From: Martyn White
Sent: 12 June 2018 16:29
To: Andrew Wood
Subject: AB/28/18/HH

The proposal affects a modern property in the Arundel Conservation Area. It relates to an existing window and door which are located on the ground floor to the rear of the property. As such they are not visible from the street.

**Proposed Ground Floor Plan.
Existing & Proposed Rear
Elevation.**

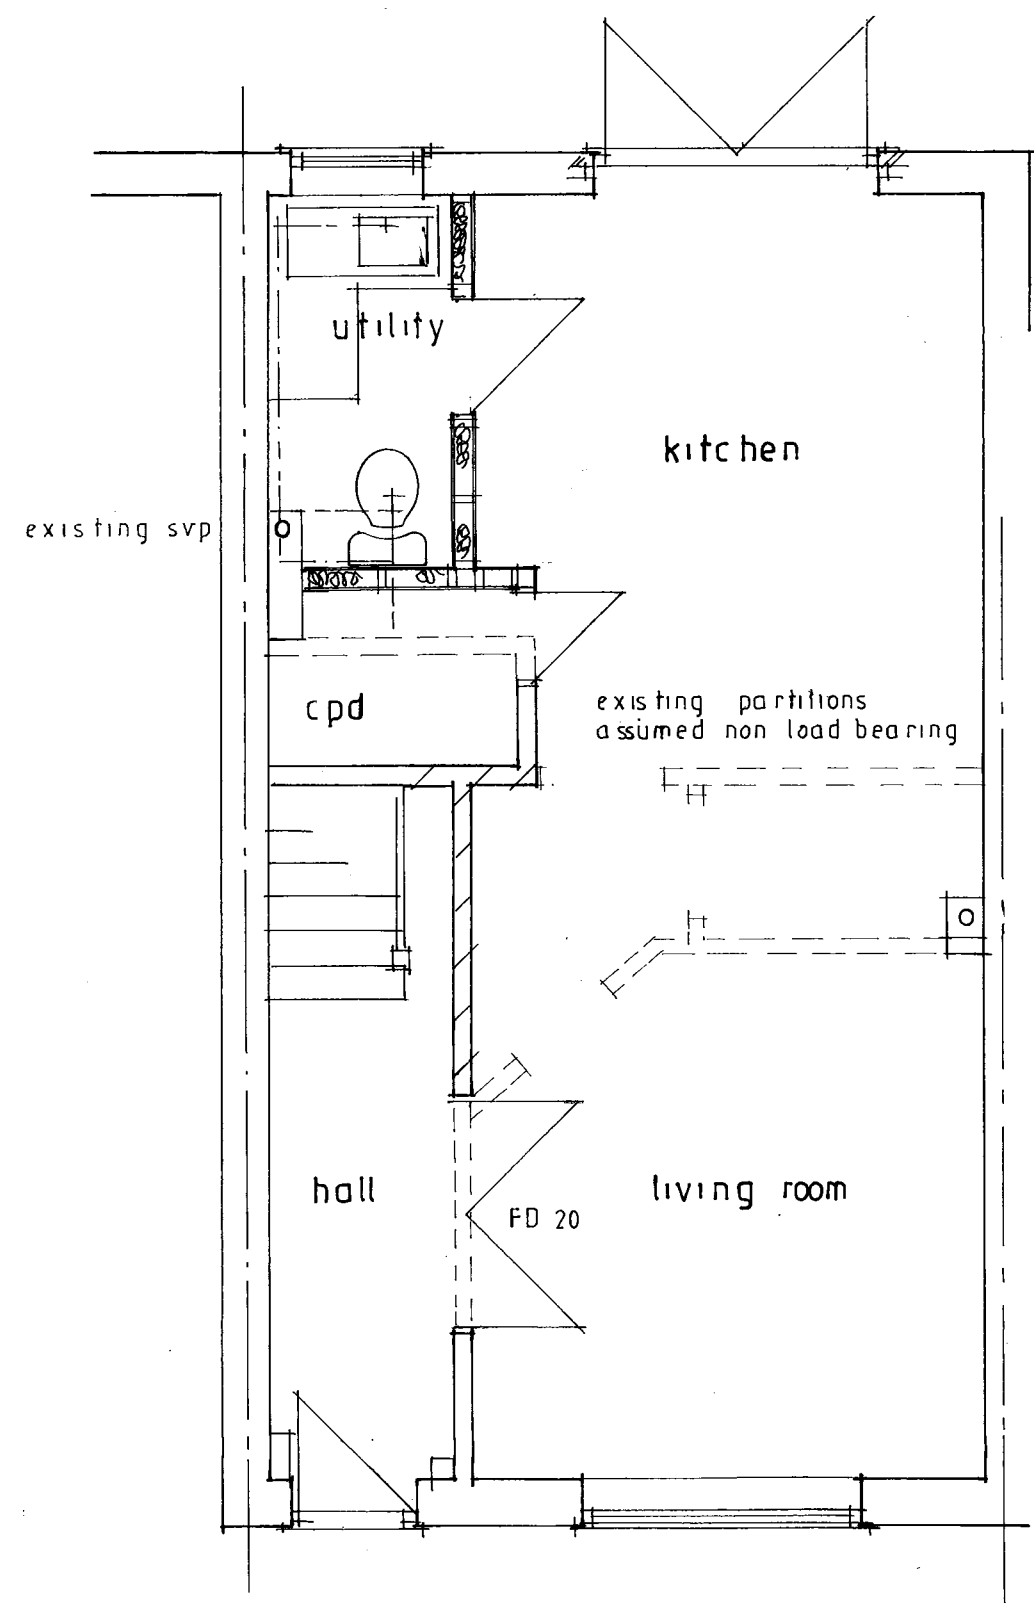
The choice of material is one that would not normally be supported. However, it is felt that as the replacement door and window will not be visible from the public highway, they are acceptable in this instance.
